Planning
Inspectorate

REPORT on the IMPLICATIONS for EUROPEAN SITES

Proposed H2Teesside

16 January 2025

Figure 23-3 (Sheet 1 of 3)

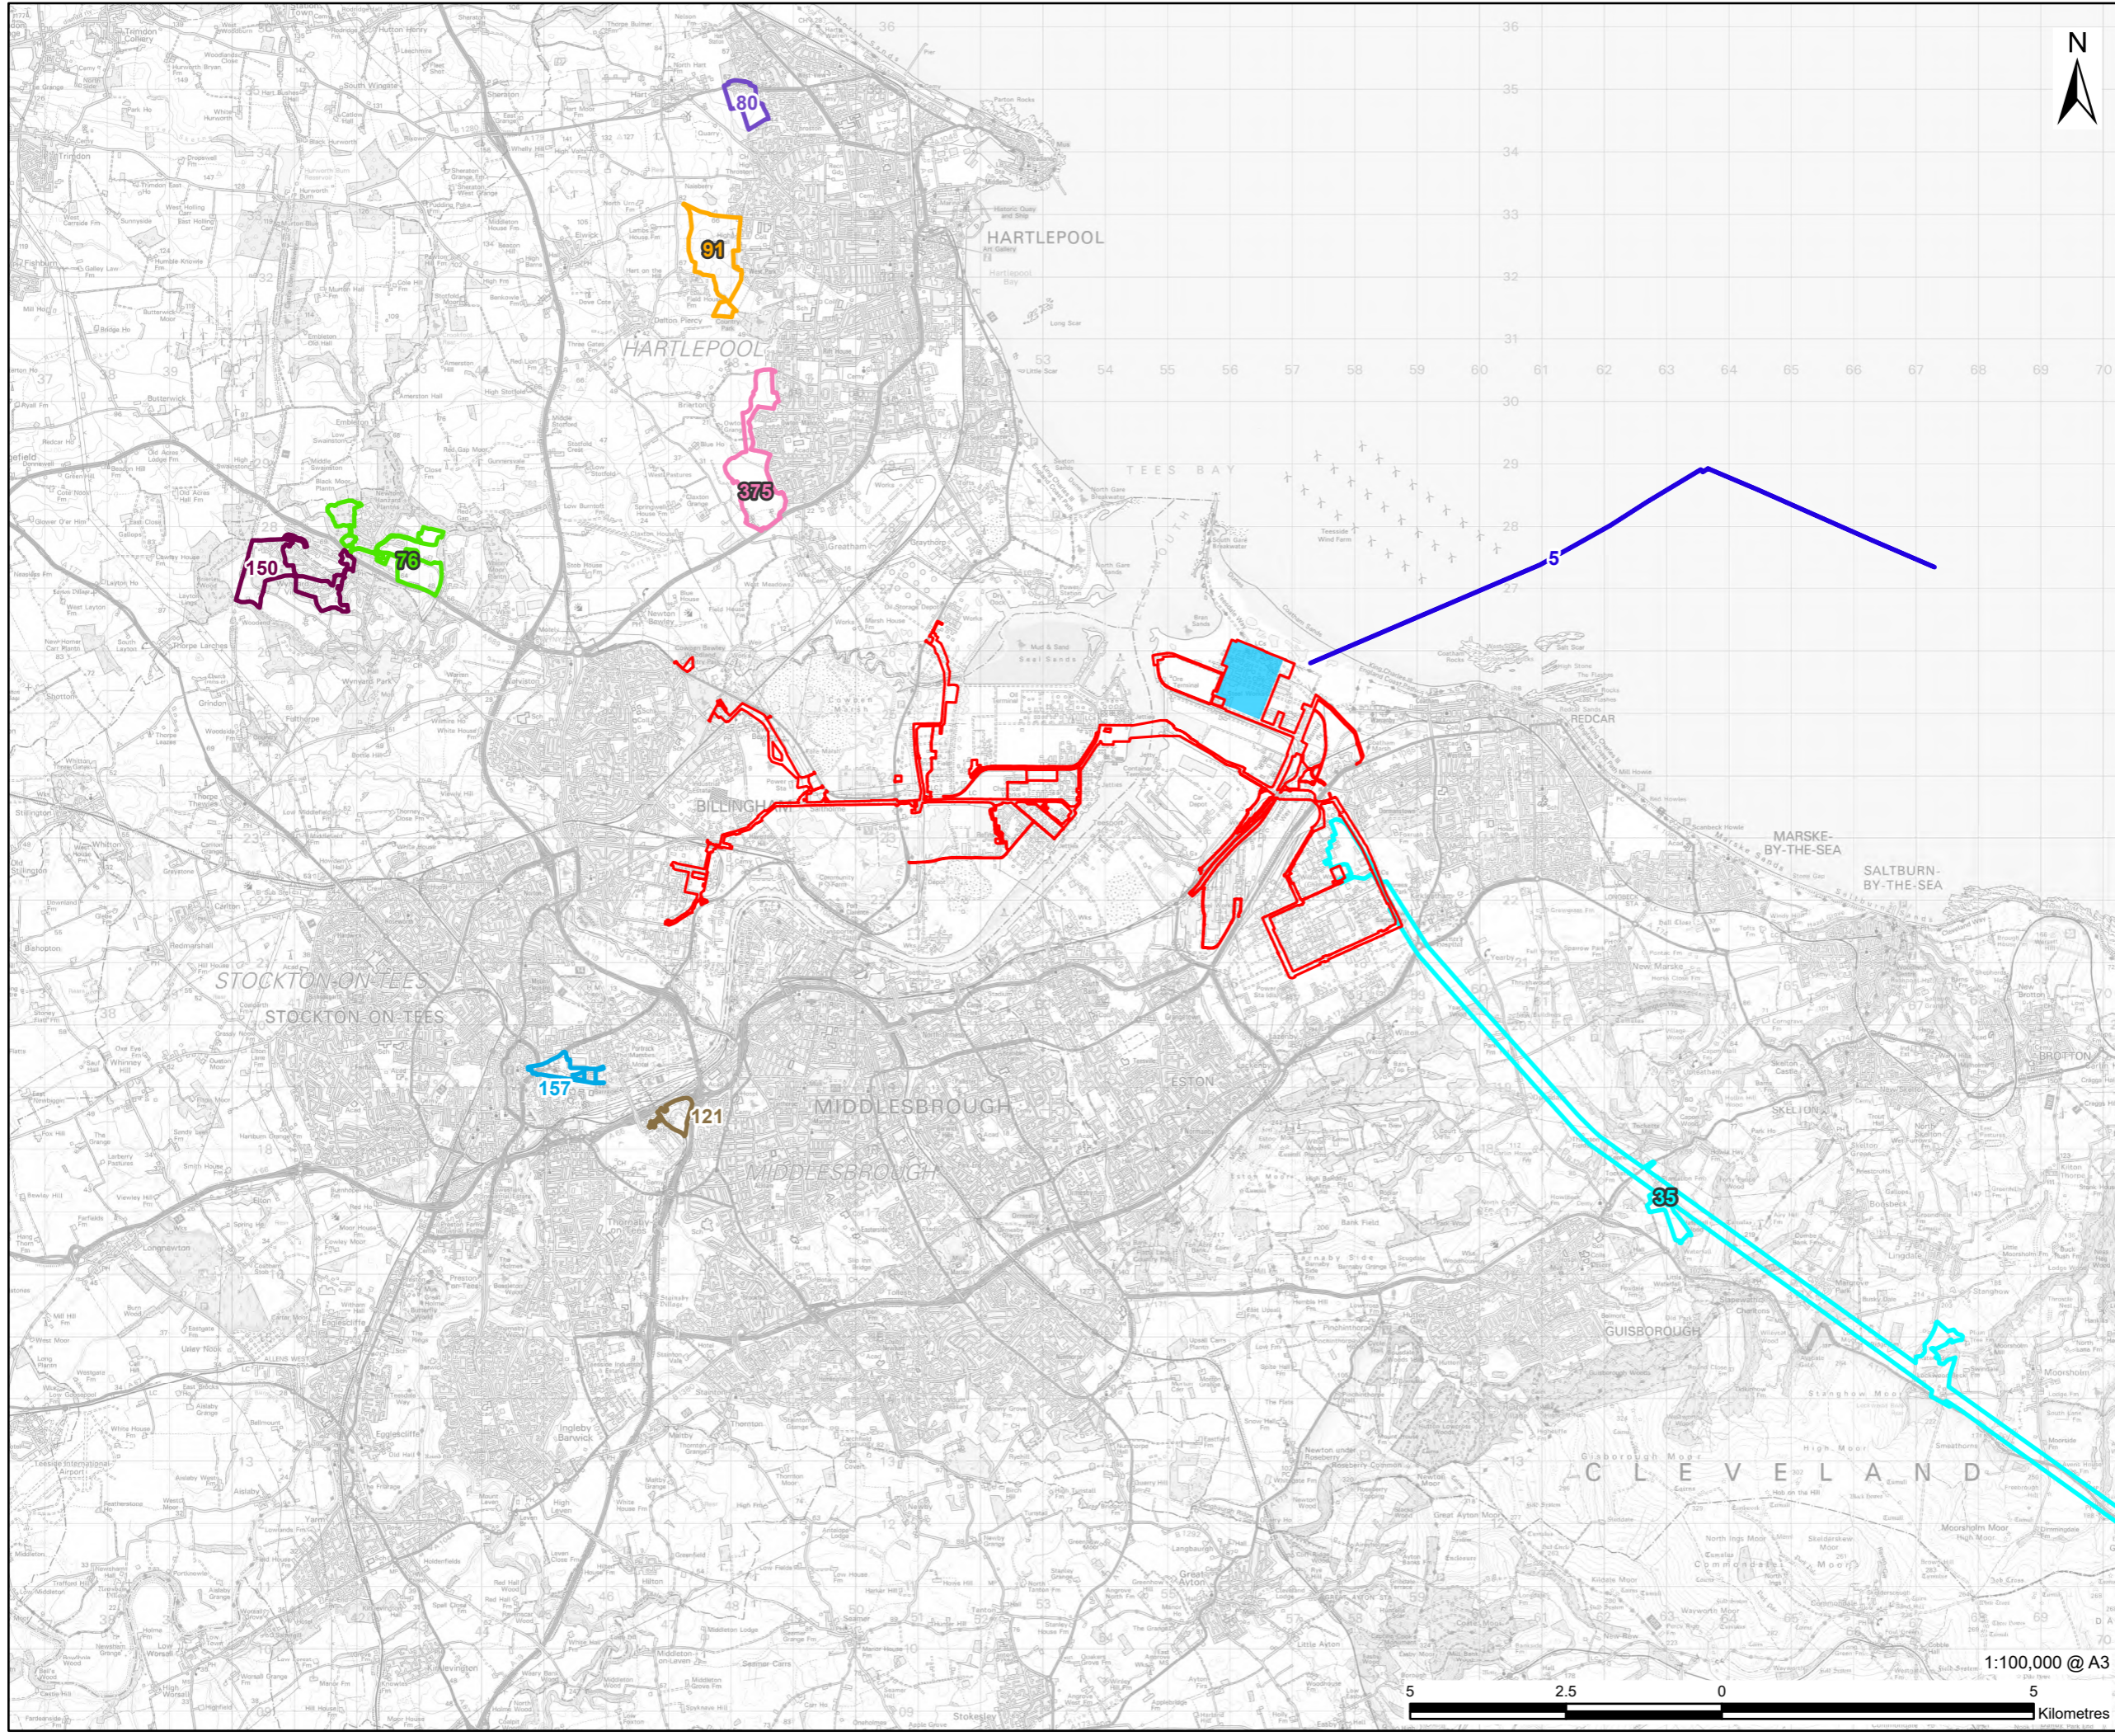
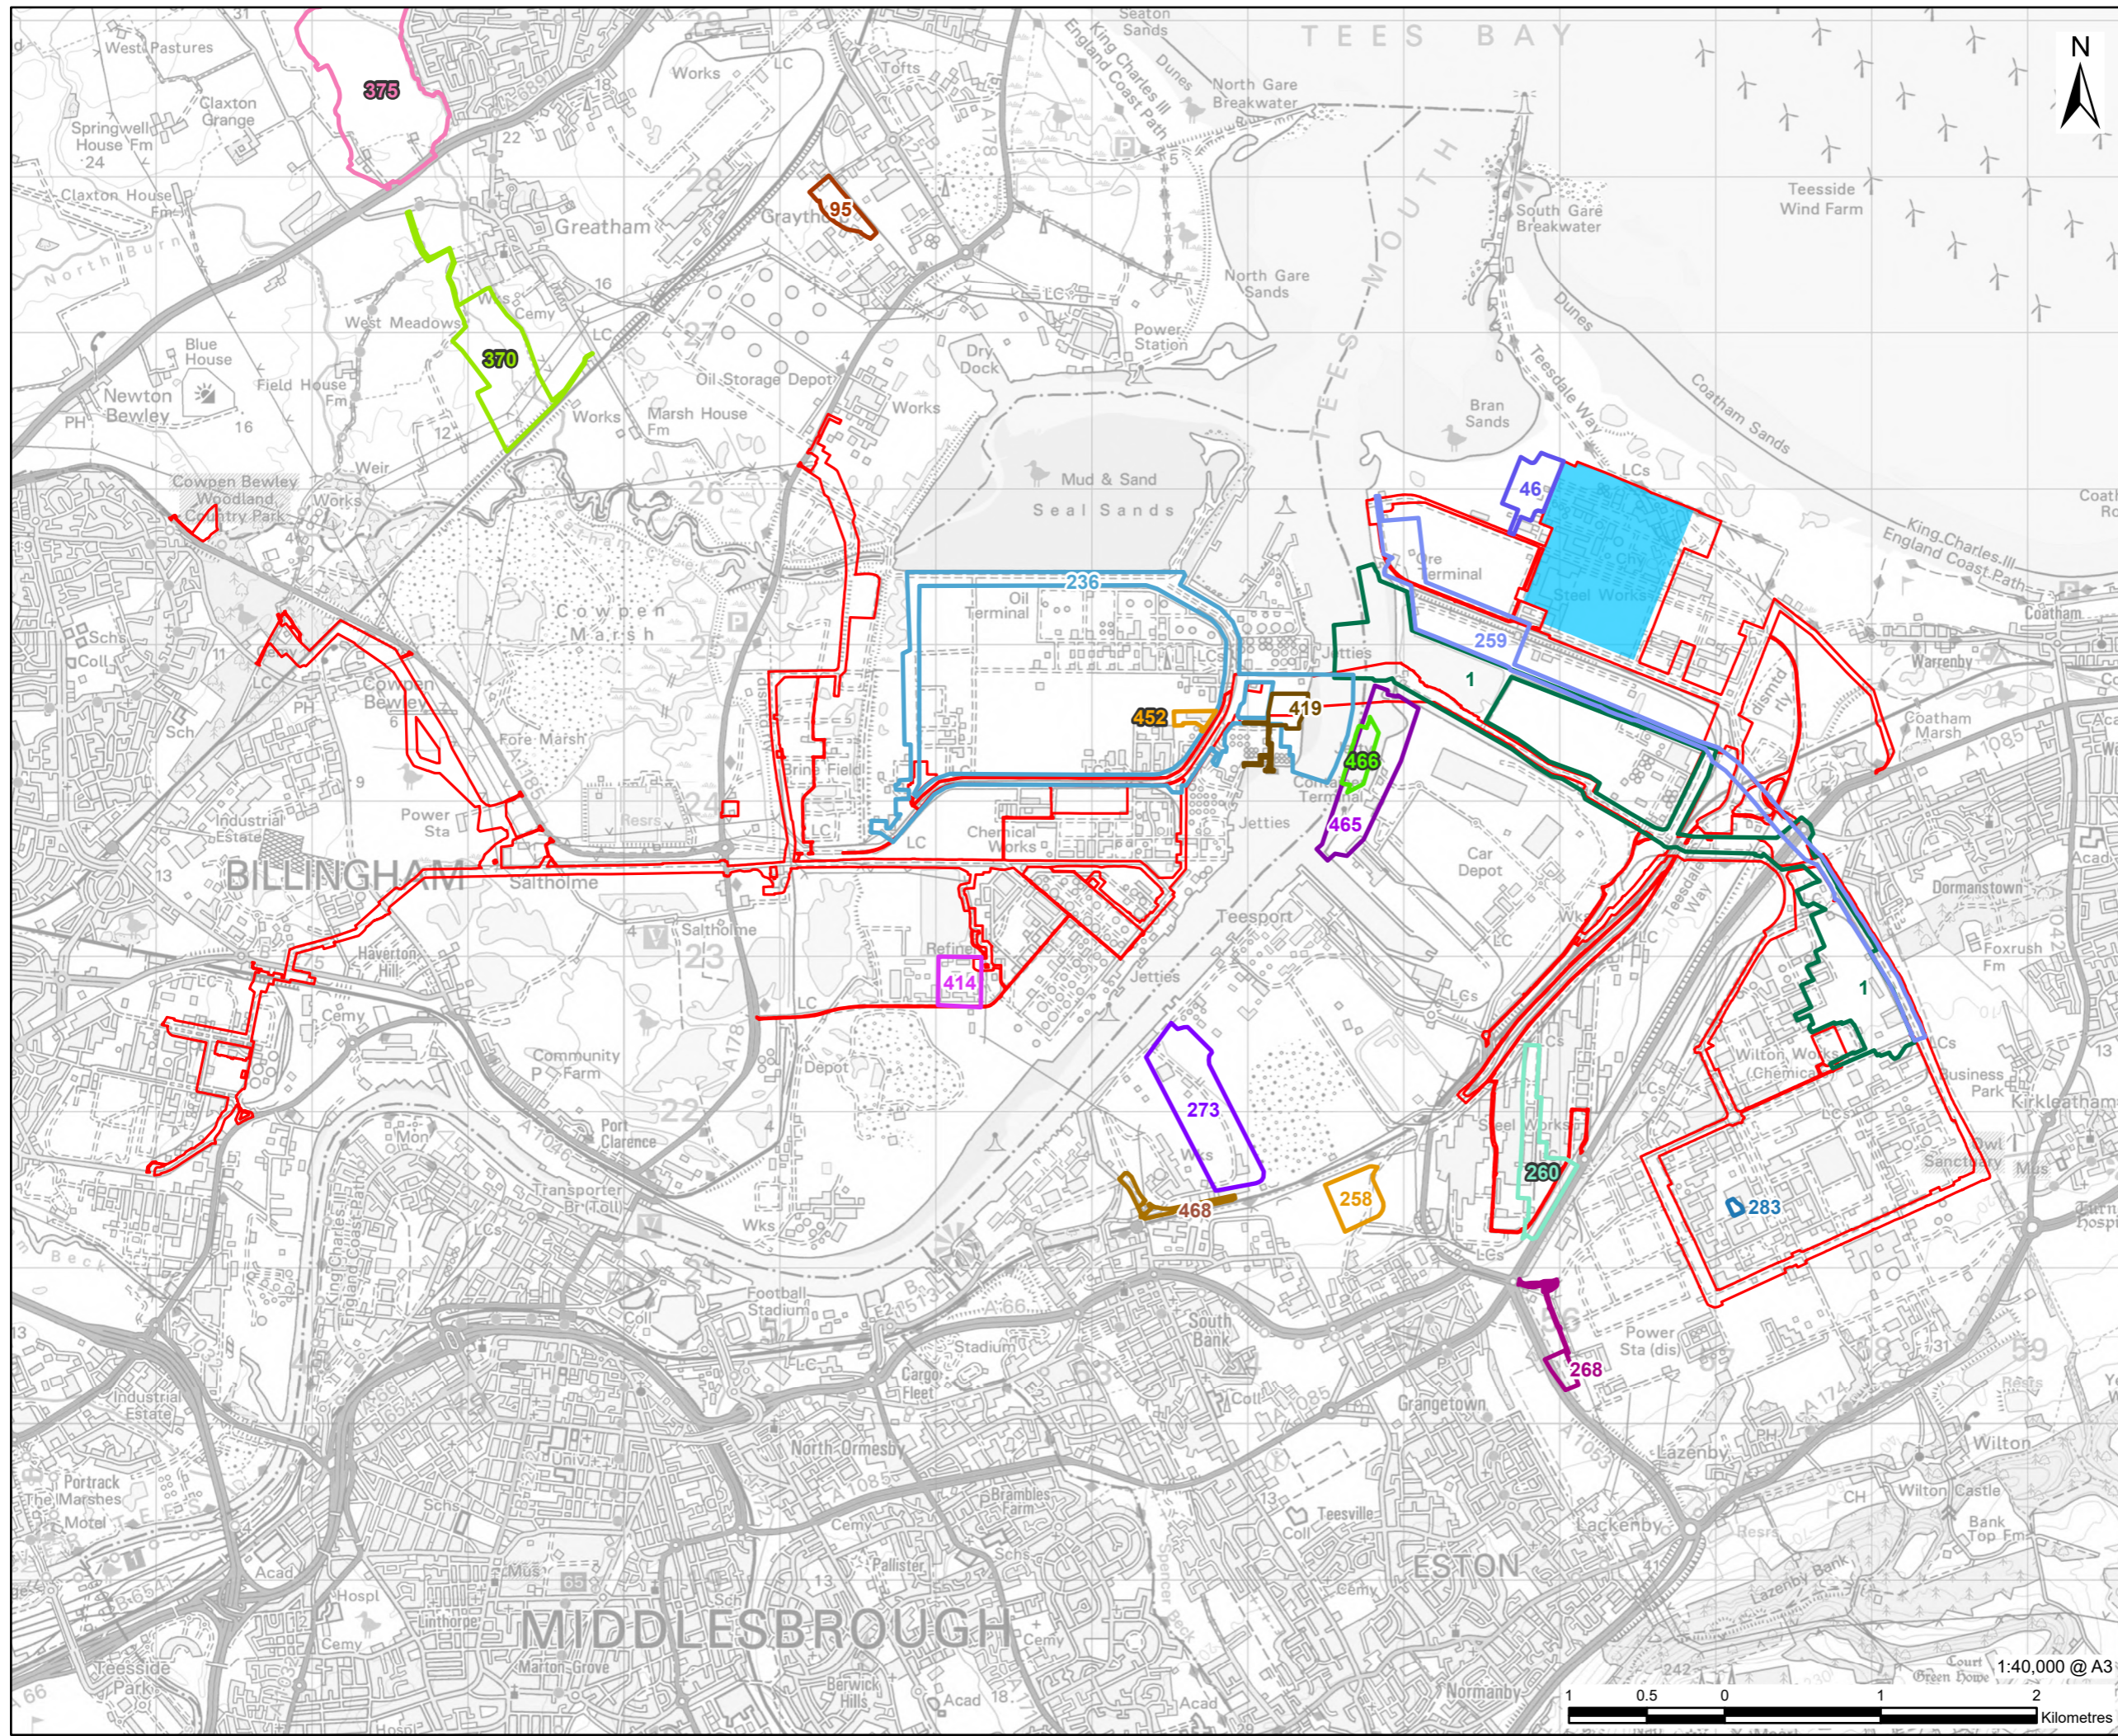
- 2.3.1 Section 5 of the HRA report [AS-016] outlined the applicant's approach to assessing in-combination effects. The projects included in the in-combination assessment were detailed in table 5-1 of the HRA Report [AS-016] and their locations depicted on Environmental Statement (ES) figure 23-3 [APP-182].
